CITY OF ALBUQUERQUE

**Re: Desert Ridge Place Unit 3 -Abrazo
Erosion and Sediment Control Plan
Engineer's Stamp Date 4-12-18 (C20E076)**

**DESERT RIDGE PLACE UNIT 3**  
**TEMPORARY EROSION CONTROL PLAN MAP**  
 PROJECT TITLE

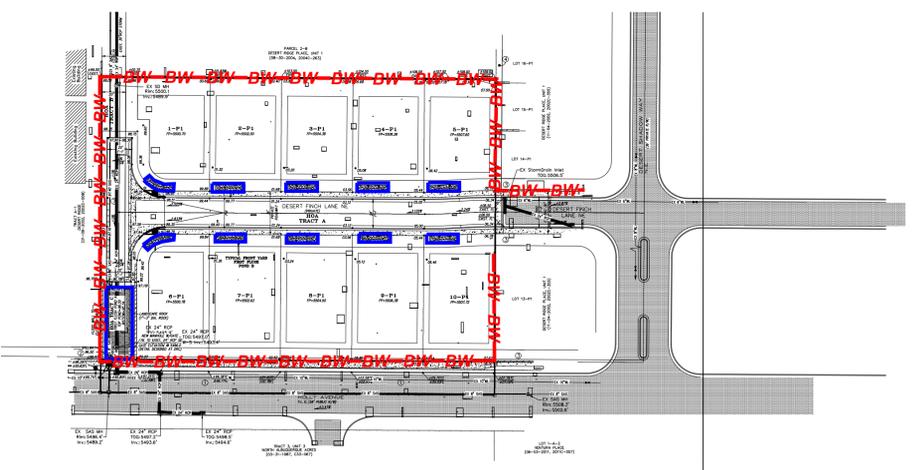
1. The main part of the plan does not show existing conditions properly. The site has a street, house pads and a pond. The site resembles the small drawing on the bottom of the page.
2. The typical lot detail does not include a sediment BMP at the front of the lot. Most builders are using a cutback behind the curb, but silt fence or mulch sock is acceptable.
3. Silt fence is not needed and most likely will not be installed at the back of the lot as there is a block wall in that location. In addition, silt fence along the high side of the lot seems unnecessary.
4. A track-out pad is shown on Holly Avenue. There is a block wall in this location.
5. The pond in the southwest corner has an opening into the storm drain system. Per as-built drawings it is approximately 9 inches above the bottom of the pond. Seems inlet protection should be installed.
